RE: CAMDEN MEDICAL CAMPUS PRECINCT-MOD-1 (SSD-7387-MOD-1)

This letter has been prepared by City Plan Strategy & Development Pty Ltd (City Plan) on behalf of the applicant, Gregory Hills Corporate Park Pty Ltd to respond to the Department's written request to provide a response to the issues raised during the exhibition of the modification application for Camden Medical Campus, Gledswood Hills (SSD-7387-MOD-1).

Appendix 1 - City Plan Response

Drawing Name:
Landscape Masterplan

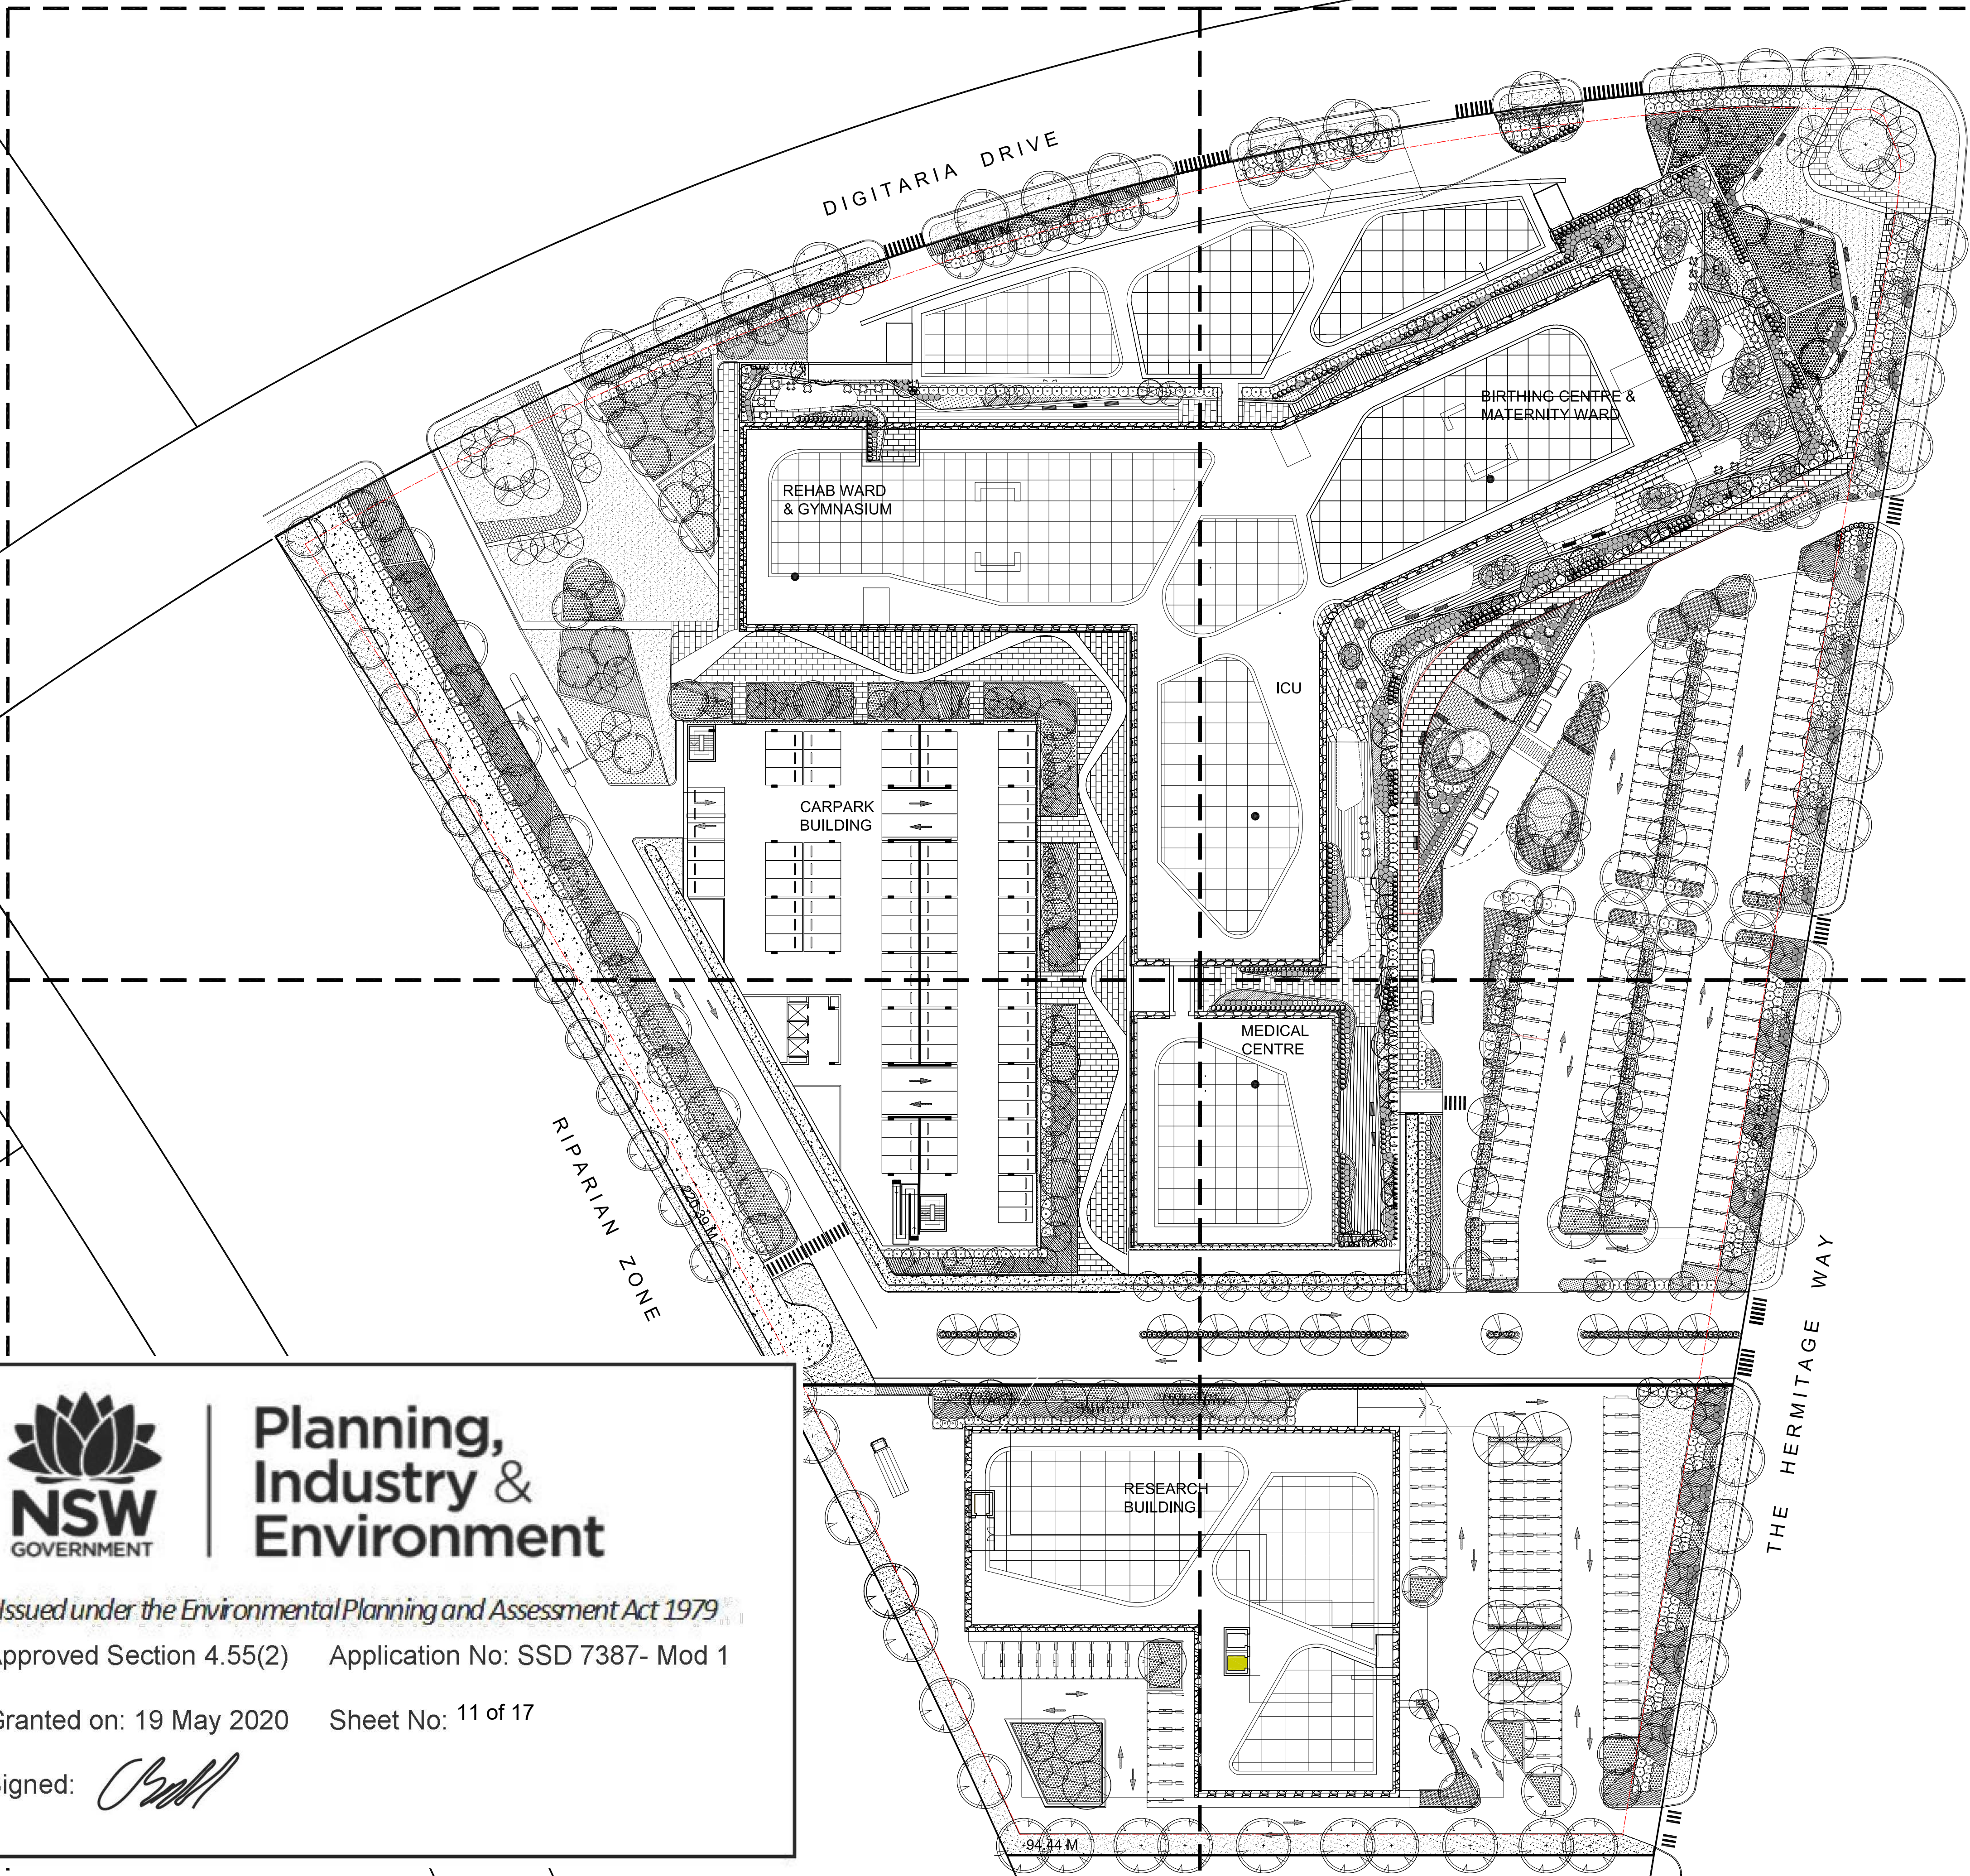
Comment	Response
1. The majority of the proposed landscaping species are suitable except for the following which perform poorly in local conditions: ▪ <i>Acer negundo</i>. ▪ <i>Corymbia gummifera</i>. ▪ <i>Eucalyptus robusta</i>. ▪ <i>Fraxinus augustifolia</i> 'Raywood.' ▪ <i>Sapium sebiferum</i>.	addressed as part of a subsequent staged development application.

2. Suitable substitutes to the species listed in point 1 above are: ▪ <i>Quercus palustris</i>. ▪ <i>Liquidambar styraciflua</i> 'Oakville Highlight.' ▪ <i>Melaleuca decora</i>. ▪ <i>Melaleuca styphelioides</i>. ▪ <i>Angophora hispida</i>. ▪ <i>Angophora floribunda</i>. ▪ <i>Angophora subvelutina</i>. ▪ <i>Corymbia citriodora</i> 'Scentuous.' ▪ <i>Eucalyptus bauerana</i>. ▪ <i>Eucalyptus viminalis</i>. ▪ <i>Eucalyptus amplifolia</i>.	Noted. This modification application relates to a Concept Application and this detail will be addressed as part of a subsequent staged development application.

3. It is recommended that at least one culturally significant signature tree be incorporated into the design, e.g. <i>Araucaria cunninghamii</i>, <i>Agathis robusta</i>, <i>Washingtonia robusta</i>, <i>Jubaea chilensis</i> or <i>Livistona australis</i>.	Noted. This modification application relates to a Concept Application and this detail will be addressed as part of a subsequent staged development application.
DPIE	
The Department also requests further information regarding parking requirements onsite and how car parking will be delivered and managed to service the proposed development staging.	Please refer to the comments provided above in response to Council's comments and the response prepared by Mott Macdonald at Appendix 2.
Public Submission	
I would like to raise concerns around parking within the Hermitage estate at Gledswood Hills, due to the construction of the hospital precinct. As is seen with Campbelltown Hospital, a lack of parking and high cost drives people to park on the streets. As the Hermitage Estate backs onto the riparian corridor adjacent the development, it's highly likely that people will choose to park in our estate and walk across the riparian corridor to the hospital. This has potential to cause traffic and parking chaos on our narrow streets and negatively impact the quality of life for residents at the Hermitage.	All parking requirements for the Camden Medical Campus Precinct are to be accommodated on the site. This application is a Concept Development Application and parking requirements required for the proposed number of staff, patients and visitors will be reviewed carefully for each subsequent staged DA. The change in land uses and subsequent reduction in gross floor area (GFA) has resulted in an overall parking requirement of 993 parking spaces for both the hospital and biomedical research uses, a reduction of 87 carparking
